Lime Down

Solar Park

Statement of Common Ground with Natural England

Planning Inspectorate Reference: EN010168

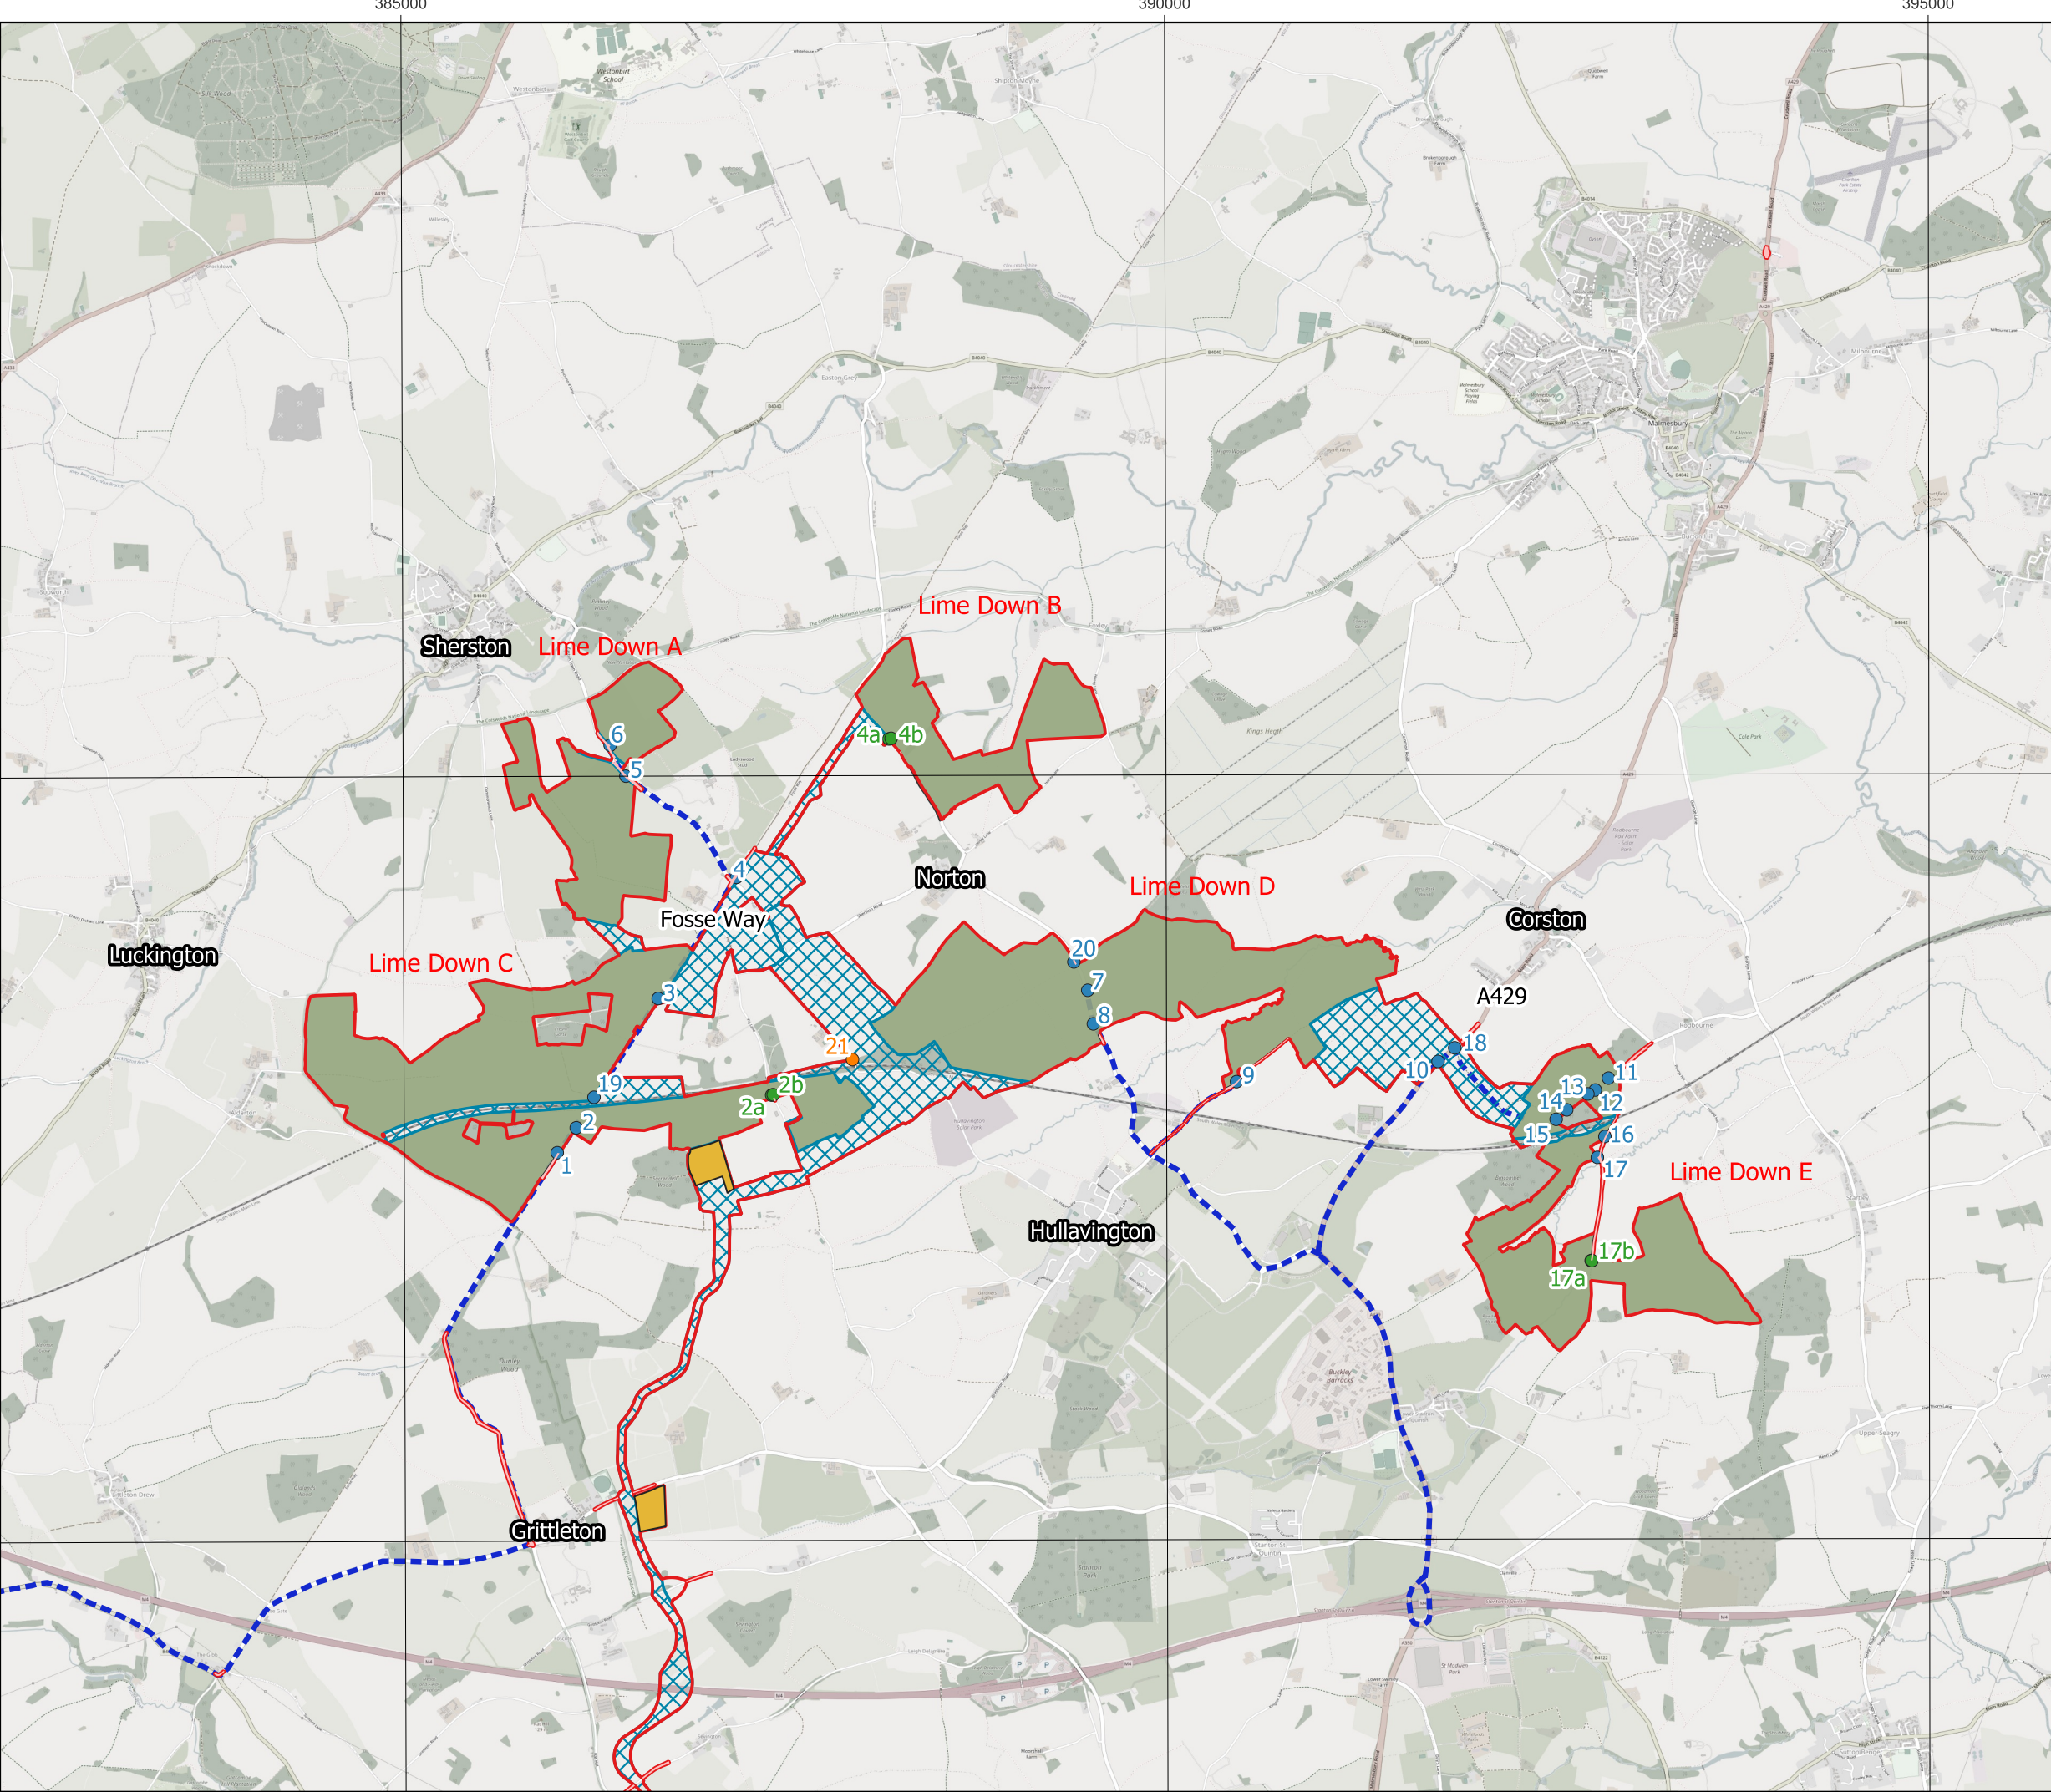
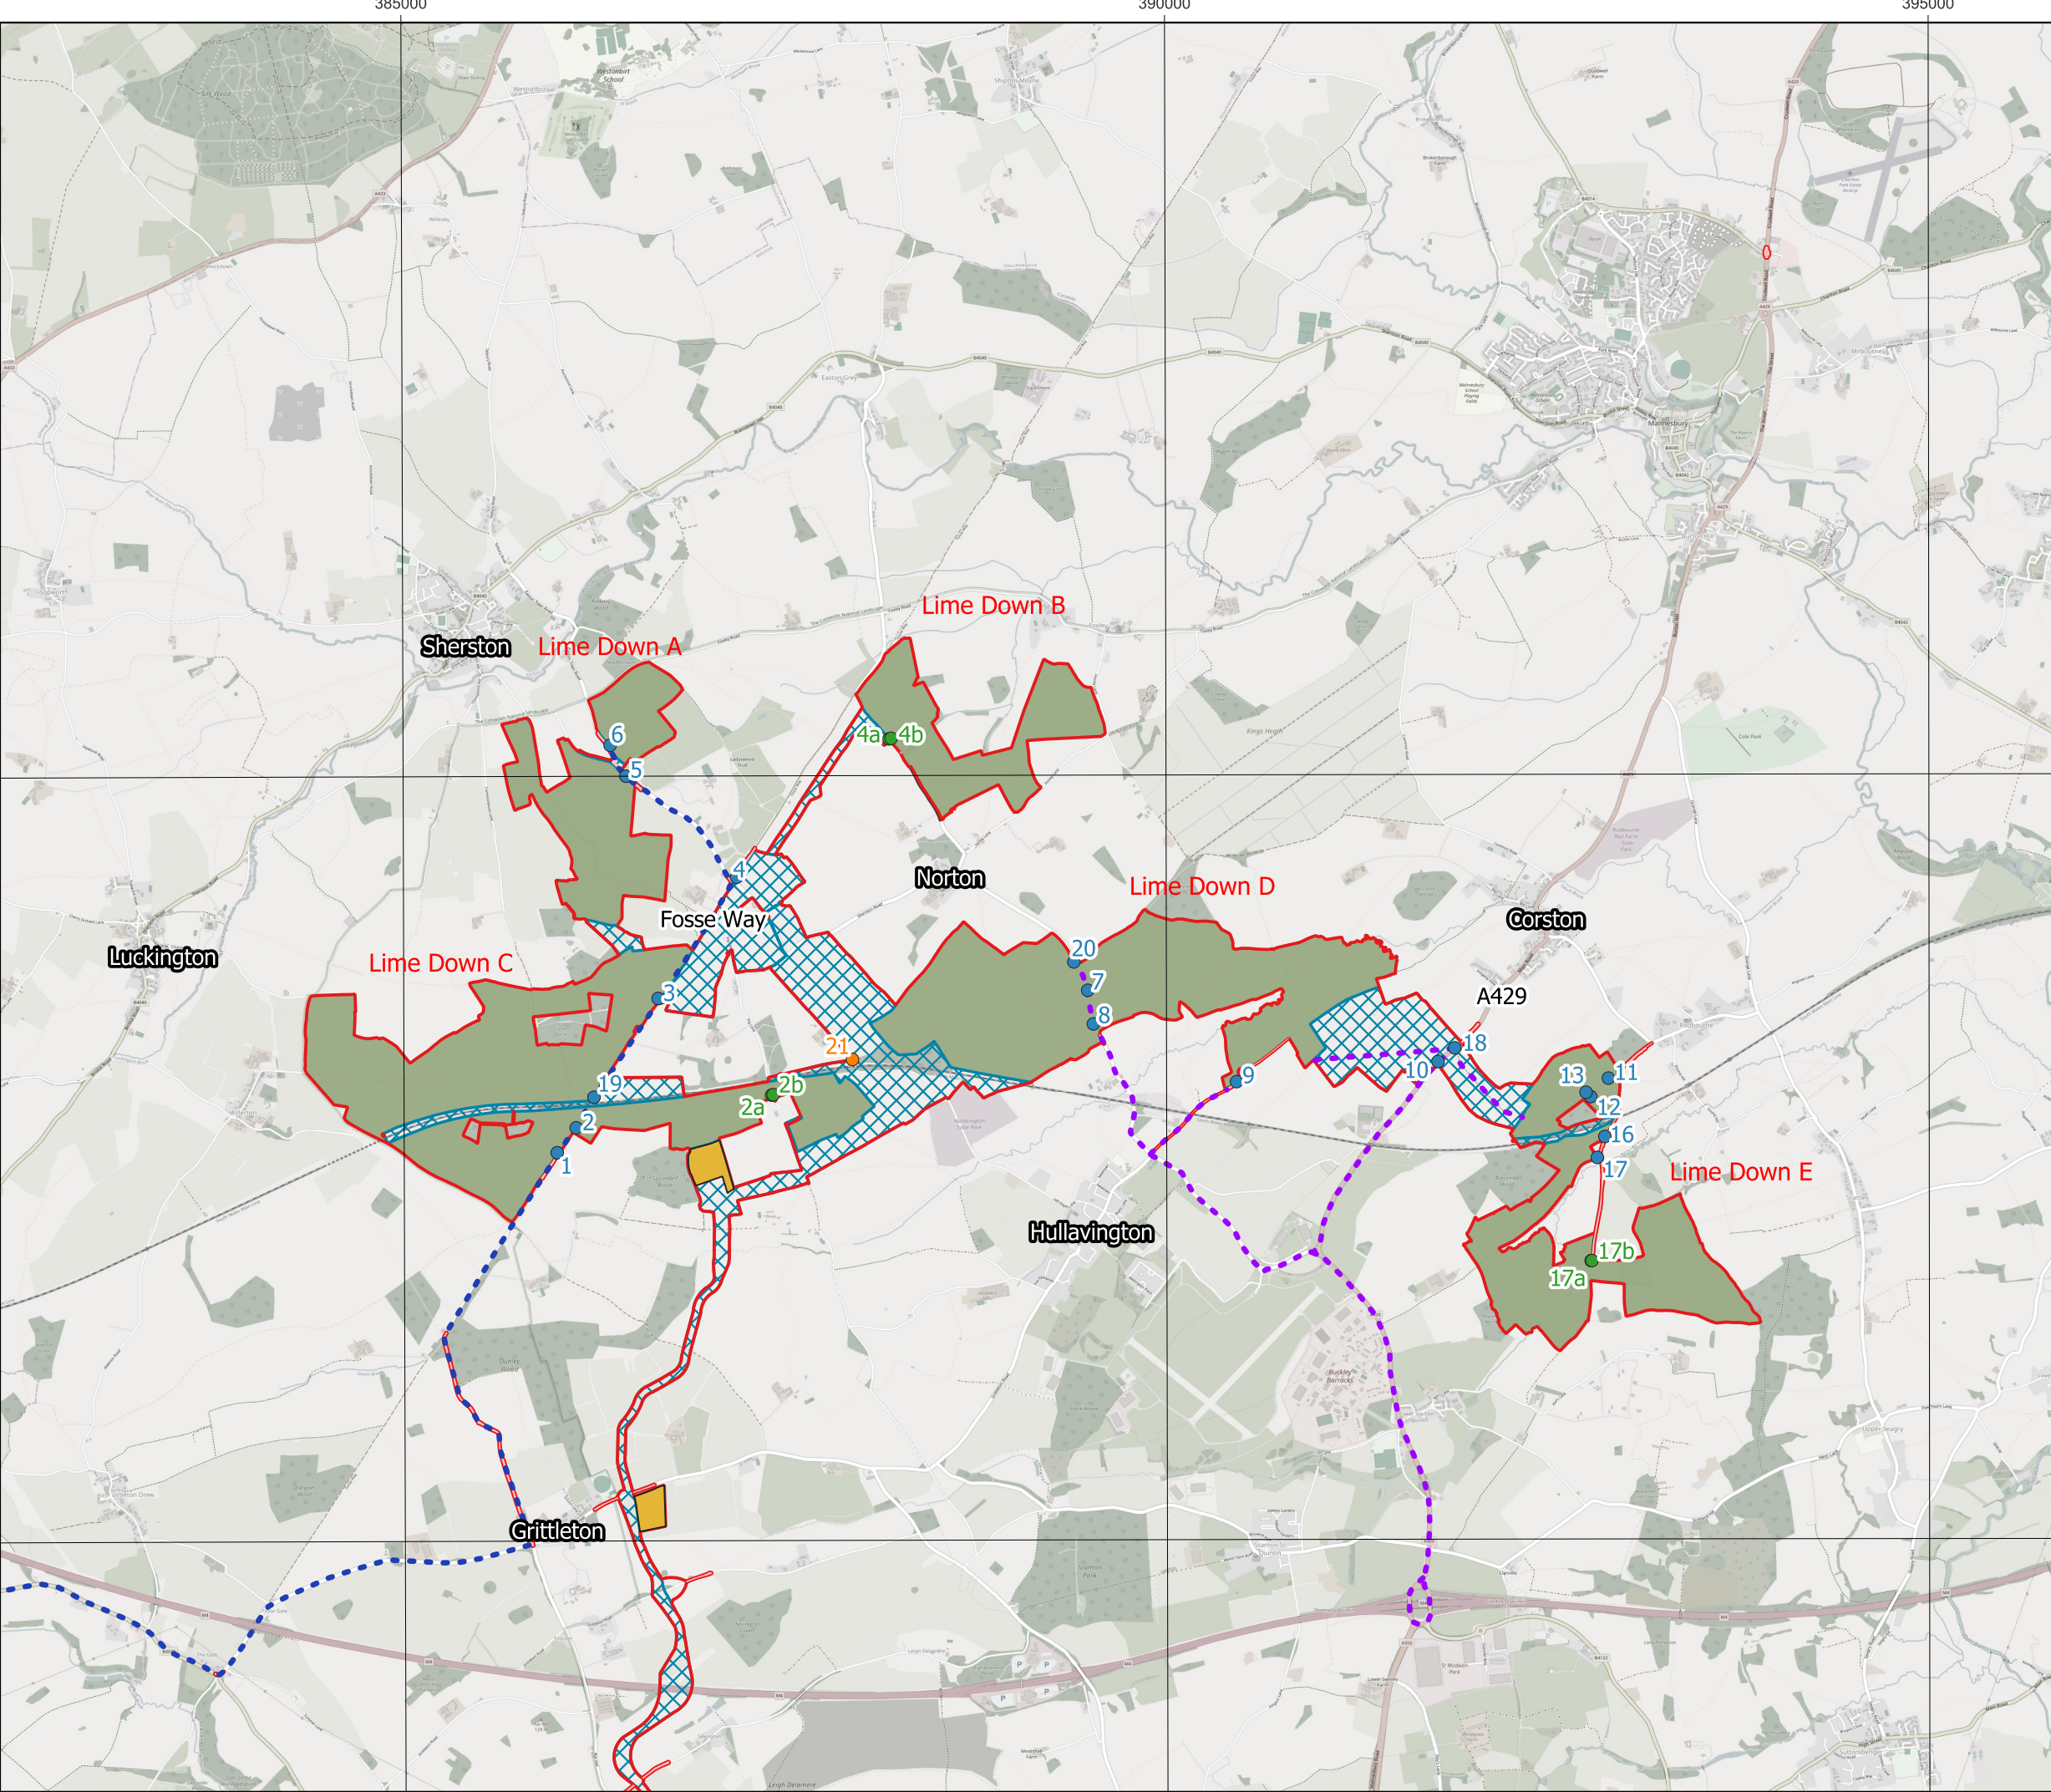
3.3.7	Assessment Results – Bath and Bradford-on-Avon Bats SAC	<p>Regarding the Bath on Bradford on Avon Bats SAC, Natural England concur with the conclusions of the HRA except regarding fragmentation effects to lesser horseshoe bat habitat within the Solar PV site where additional mitigation measures have been suggested.</p> <p>Natural England is not satisfied that it can be excluded beyond reasonable scientific doubt that the project would not have an adverse effect on the integrity of the Bath and Bradford on Avon.</p> <p>Natural England agrees with the scope of the Habitats Regulations Assessment, including the Zone of</p>	<p>The Applicant agrees that impacts to functionally linked land, where such land supports the populations associated with the SAC population, could affect the integrity of the SAC.</p> <p>The Applicant concurs that relative activity levels and timing of lesser horseshoe bat calls recorded at Lime Down C are indicative of a lesser horseshoe bat roost close to the Order Limits in this location.</p> <p>Following a meeting held with Natural England on 18 May 2026, the Applicant has concurred with Natural England on this matter and has agreed to assess Lime Down C as potentially representing functionally-linked land for</p>	Under Discussion

Reference	Sub-topic	NE Position	Applicants Position	Status
		<p>Influence and the list of internationally designated sites, and confirms that Salisbury Plain SPA can be scoped out.</p> <p>For the Bath and Bradford on Avon Bats SAC, Natural England agrees that the solar PV site itself is not functionally linked land for greater horseshoe bats. However, the cable route corridor lies within an impact zone and could be functionally linked, meaning likely significant effects cannot be ruled out due to potential loss or fragmentation of commuting habitat. Impacts relating to loss of roosts, killing, or injury of greater horseshoe bats can be screened out.</p> <p>In relation to lesser horseshoe bats, while the HRA concludes the solar PV sites are not functionally linked, Natural England notes survey evidence showing regular early-night activity at Lime Down C, suggesting nearby roosting and potential functional linkage to the SAC. Although loss of foraging habitat is unlikely to result in</p>	<p>lesser horseshoe bats associated with the Bath and Bradford-on-Avon Bats SAC. An updated version of the Habitat Regulations Assessment Report [APP-275] will be prepared accordingly and submitted at Deadline 3.</p> <p>Natural England and the Applicant have reached agreement on the mitigation measures which would need to be included within Lime Down C to ensure that significant impacts to SAC lesser horseshoe bats resulting from fragmentation could be avoided.</p> <p>These measures comprise:</p> <ol style="list-style-type: none"> a. Retention of hedgerows across Lime Down C with any required new gaps in hedgerows to be limited to a maximum of 10m (it is understood that a majority will be limited to 3.5 – 6m) with the exception of one larger gap of 12 – 14m for the proposed access off the Fosse Way.

Reference	Sub-topic	NE Position	Applicants Position	Status
		<p>significant effects, potential fragmentation of commuting routes within Lime Down C should be screened in for Appropriate Assessment.</p> <p>For Bechstein’s bats, Natural England agrees that likely significant effects from loss or change to functionally linked land can be screened out due to distance, lack of suitable habitat, and absence of records. Evidence to date does not indicate functional linkage to the SAC, and impacts related to fragmentation, roost loss, or killing and injury are considered unlikely.</p>	<p>b. Construction Lighting will be controlled to prevent light spill onto suitable commuting habitats.</p> <p>The Outline Ecological Protection and Mitigation Strategy (EPMS) [REP1-106] details how sections of hedgerow to be permanently removed for new internal access tracks where no existing gap is present will typically be between 3.5 m to 6 m wide, with a maximum of 10 m of hedgerow to be removed in any one location for this element of the Scheme. It also details how sections of hedgerow to be removed to provide access from the existing highway network, including for Abnormal Indivisible Loads (AIL) will require a maximum of 18 m of hedgerow loss at any one access point, although would typically be less than this at most access points. At Lime Down C one AIL Location is expected to comprise a gap of 12 – 14 m in width, at Solar PV Access Location 19 (ES Volume 2, Figure 13-11 Construction Access Locations:</p>

Reference	Sub-topic	NE Position	Applicants Position	Status
			<p>Solar PV Sites [APP-156] refers). Appropriate limitations and controls for the use of artificial lighting during construction, designed to avoid impacts on bats and other light-sensitive species are detailed within the Outline EPMS [REP1-106] as well as the Outline Construction Environmental Management Plan (CEMP) [REP1-096].</p> <p>Measures set out within the Outline EPMS [REP1-106] and the Outline CEMP [REP1-096] are secured by Requirements 8 and 13 respectively within the Draft Development Consent Order [REP1-007].</p> <p>The Applicant will continue to engage with Natural England on this matter and welcomes Natural England's review of the revised Habitat Regulations Assessment Report [APP-275] to be submitted at Deadline 3, at which point it is anticipated that full agreement on this matter can be reached with both parties.</p>
